A/44/26/PL Questions in relation to infiltration testing

For the avoidance of doubt, this is neither in support of nor in opposition to the application. This correspondence seeks, again, to urge the Council to respond to key questions which have been asked in relation to the pivotal infiltration testing upon which the current drainage design is based.

DRAINAGE (SHEET 1)

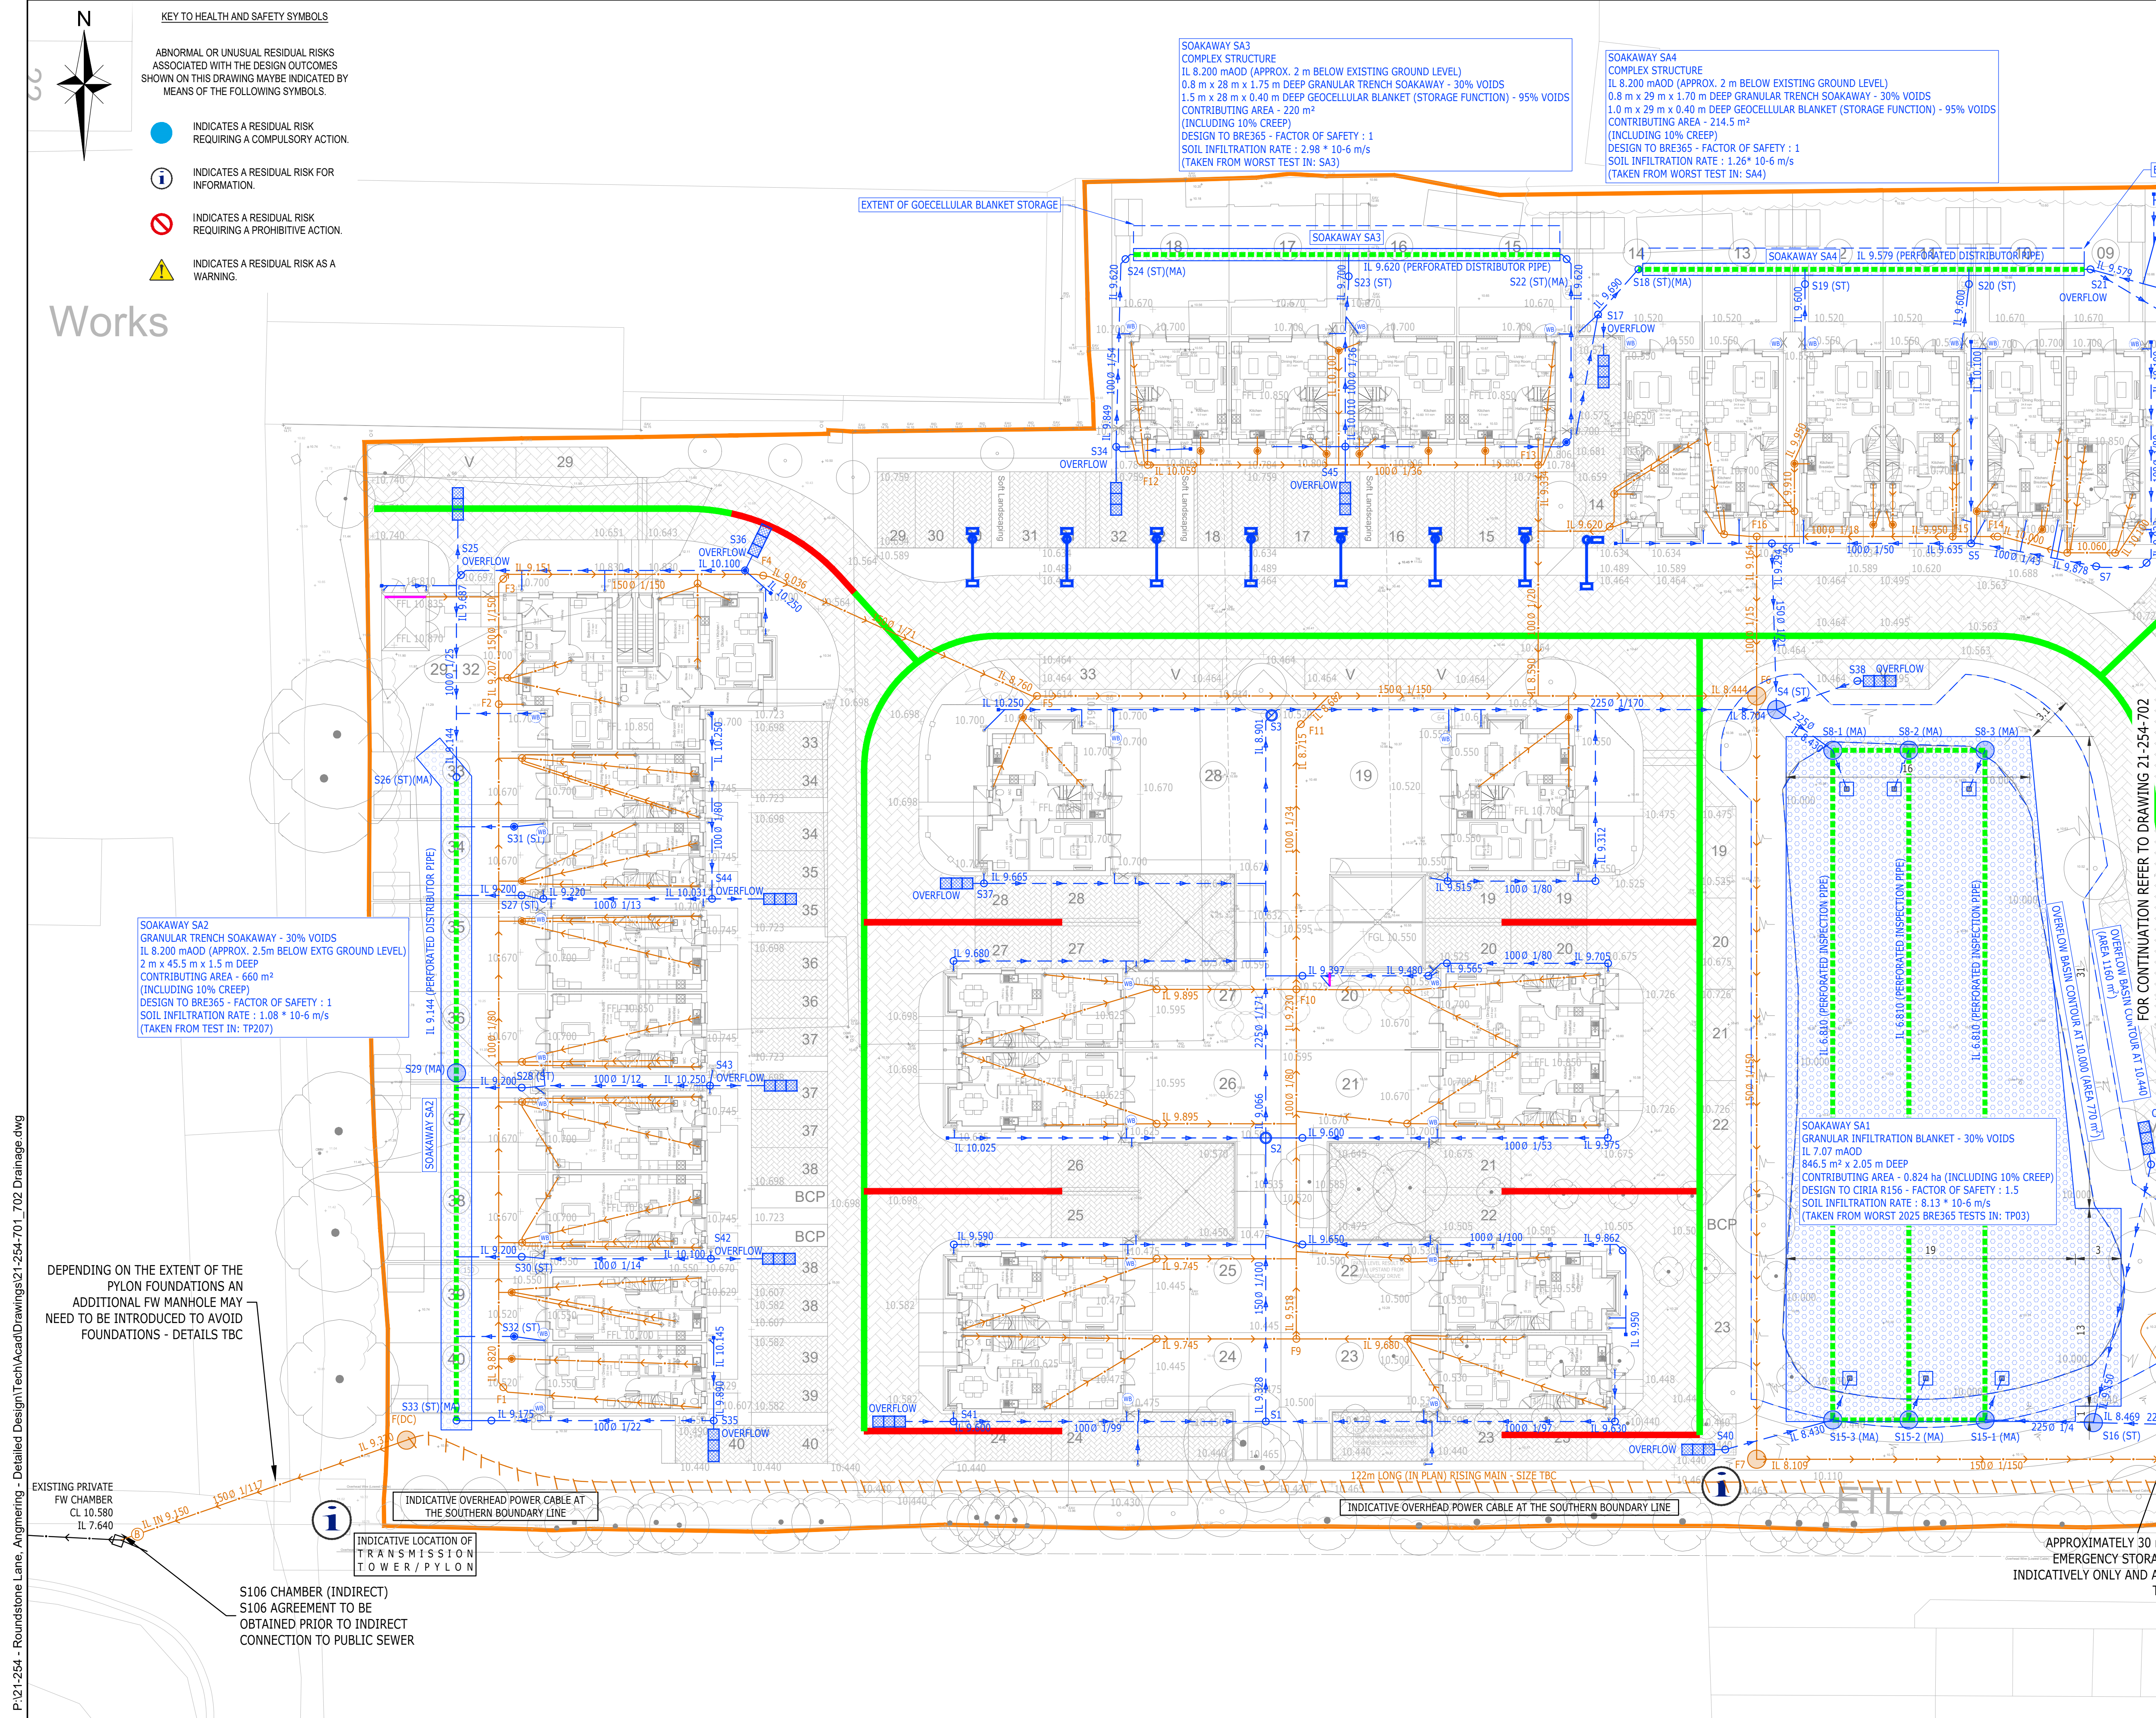
As SA1 is now the single point of failure, it's performance under extreme conditions is critical; any inaccurate infiltration rates could have a devastating effect on the residents, both physically and financially.

Given that the design already states that there is one pipe categorised as "FLOOD" and others as "FLOOD RISK", if the infiltration rate derived from this third test is overly optimistic, it logically follows that SA1 will not drain down as quickly as anticipated. Extrapolating this, it is therefore

equally logical to say that this would result in more pipes being flagged as "FLOOD" and may, of course, result in physical flooding on site.
